**DECISION DELEGATED TO DEVELOPMENT MANAGER****DECISION DELEGATED TO DEVELOPMENT MANAGER**

**Application No:** H13-0258-20      **Applicant:** Miss Gregg

**Proposal:** Single storey rear extension, garage conversion and pitched roof replacing the flat roof

**Location:** 17 Hatt Close Moulton Spalding

Drawing No:595/3 PP

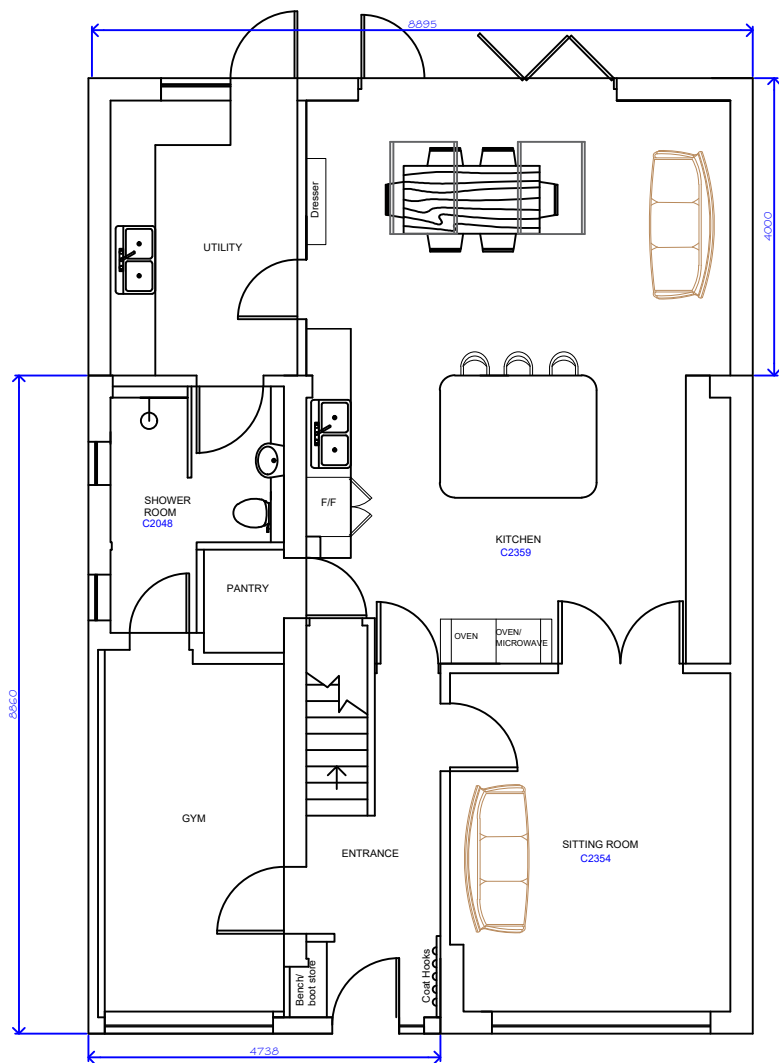
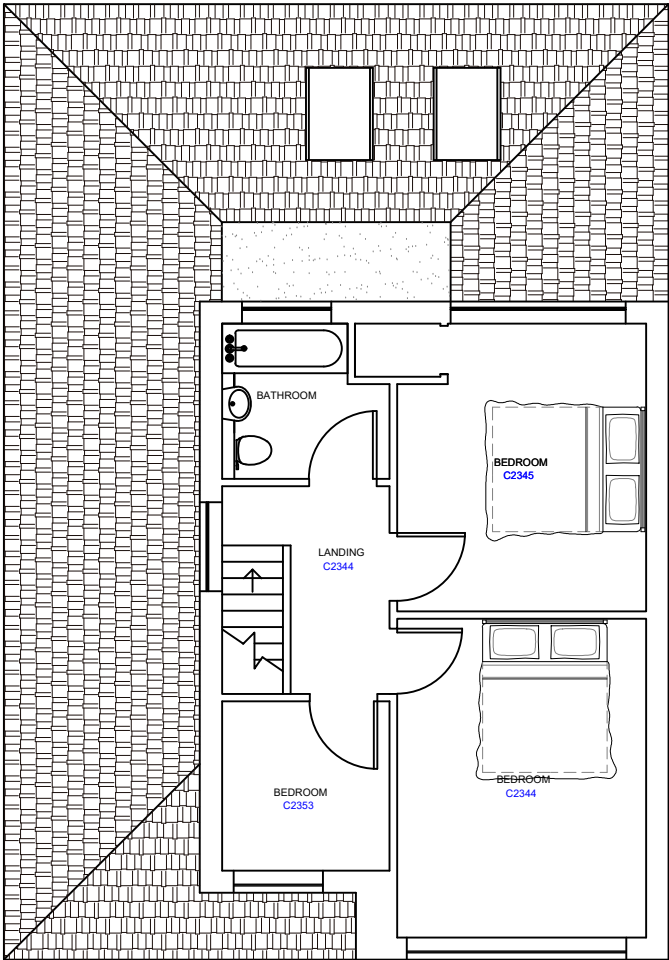
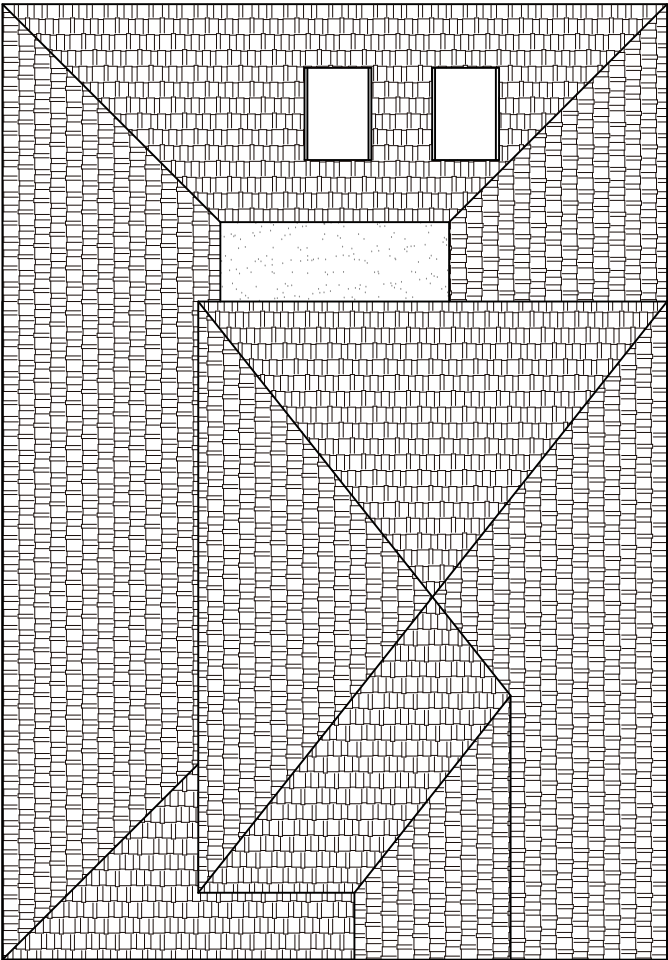
The proposed extension will protrude 4 metres from the original rear wall of the house and extend across the full width of the property. The apex height will be approx. 3.29 metres and the eaves 2.1 metres high. The existing flat roof above the garage and utility room will be replaced with a pitched roof which will be as high as that of the rear extension. Overall, it is considered that the development will be subservient to the host property in terms of scale, mass and bulk.

A half pitch roof will extend from the front to the rear through the northern side elevation. It will cover the existing flat roof in-built garage as well as the intended rear extension. In the interest of good design standards, the highest points of such canopy roof will slightly vary in order to not collide with the lowest parts of the first-floor windows. In general, the proposed roof will not appear at odds with the existing main roof which also has a hip pitch.

Internally, the development is aimed to create a large open space for accommodating kitchen and dining as well as a new shower room. The proposed works for the garage conversion entails the marginal width reduction of such space from 2.64 to 2.59 metres. The internal room will be used for private gym. No alterations will be carried out for the internal distribution on the first floor.

The proposed extension will be set back in the region of 1.40 metres from the southern boundary and 1.20 metres from the northern boundary. The separation distances will be approx. 7.65 and 7.85 metres with the opposing elevation to the north (No. 19) and south (No. 15) respectively. Having also regard to the single-storey nature of the extension, the development will not create any overbearing impact upon the residents of adjacent properties.

There are two first-floor openings on the opposing elevation. After reviewing the determined plans of approved two-storey side extension to the house No. 19 (H13-1512-88), the existing slot window is for a bedroom and a standard-sized windows for landing. The proposals for raising the flat roof to half hip pitch on the northern side elevation will be such that the resulting height will not be excessive and, in addition to the mentioned above regarding the opposing windows, the new roof will not be significantly visible for the house occupiers of No. 19.
